PLANNING AMENDMENT

| SITE ADDRESS DETAILS Bridge Hotel, Bridge Road, Sutton Bridge, Lincolnshire, Spalding, PE12 9UA | | | |
| CURRENT APPLICATION NO: This amendment cannot be considered unless the relevant reference is stated. | | H18-0463-24 | |

| FULL DESCRIPTION OF DEVELOPMENT OF CURRENT APPLICATION THAT THIS AMENDMENT RELATES TO | Change of use from hotel Class C1 to residential Class C3 including the creating of 15 residential units | |

GROUND FLOOR PLAN @ 1:100

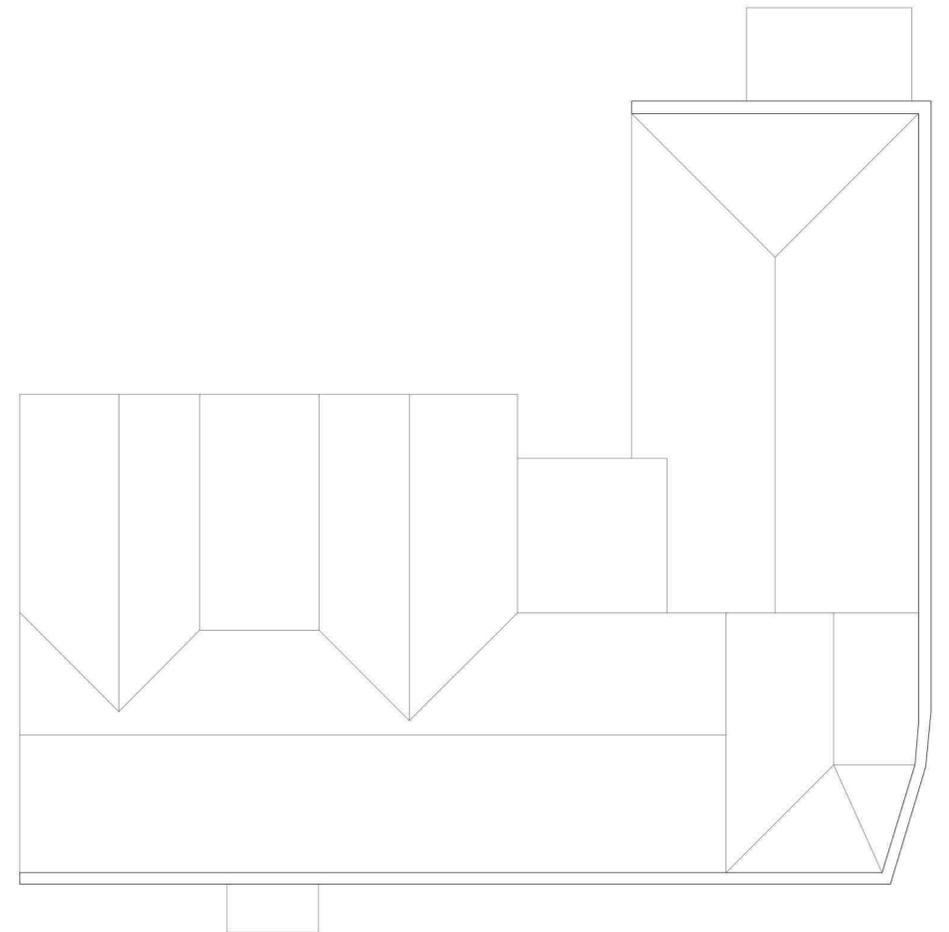
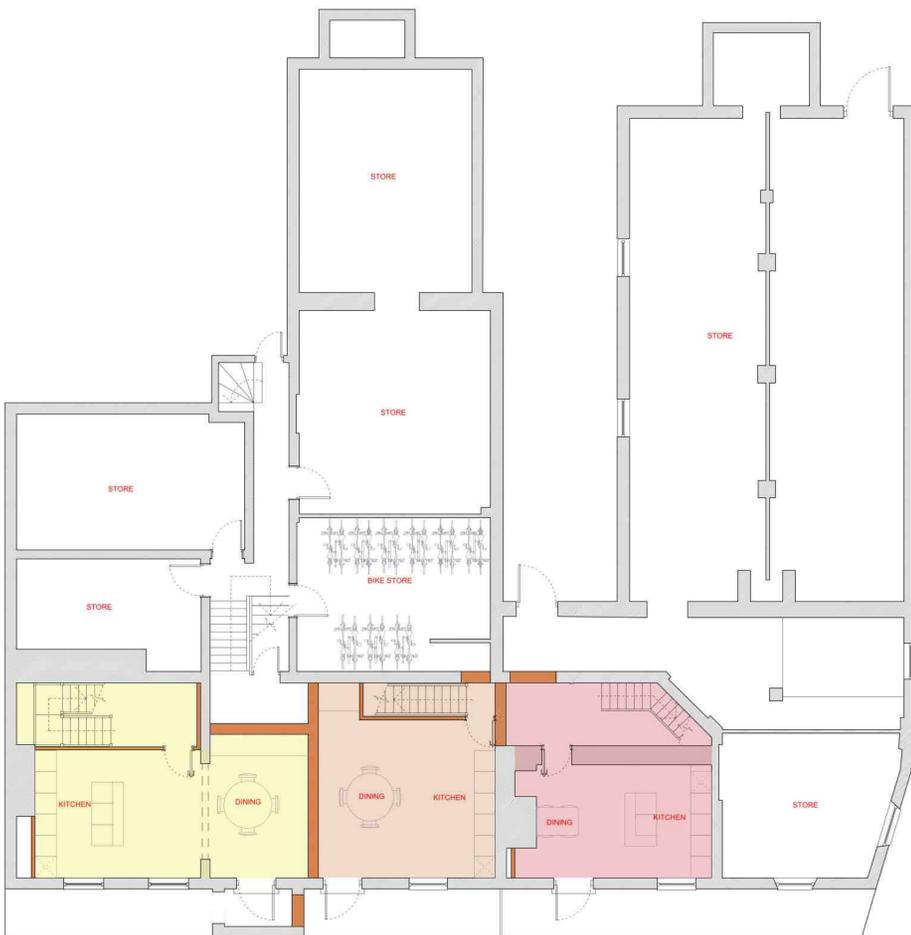
| State details of amendments proposed. (Give a full detailed list of the changes; and also mark these clearly on the accompanying plans. Only the changes listed here will be considered) | Floor levels and window sills raised to align with the floor risk assessment | |
| State drawing numbers of the current submission | 723-04-D- Proposed Plans, 723-05-A- Proposed Elevations | |
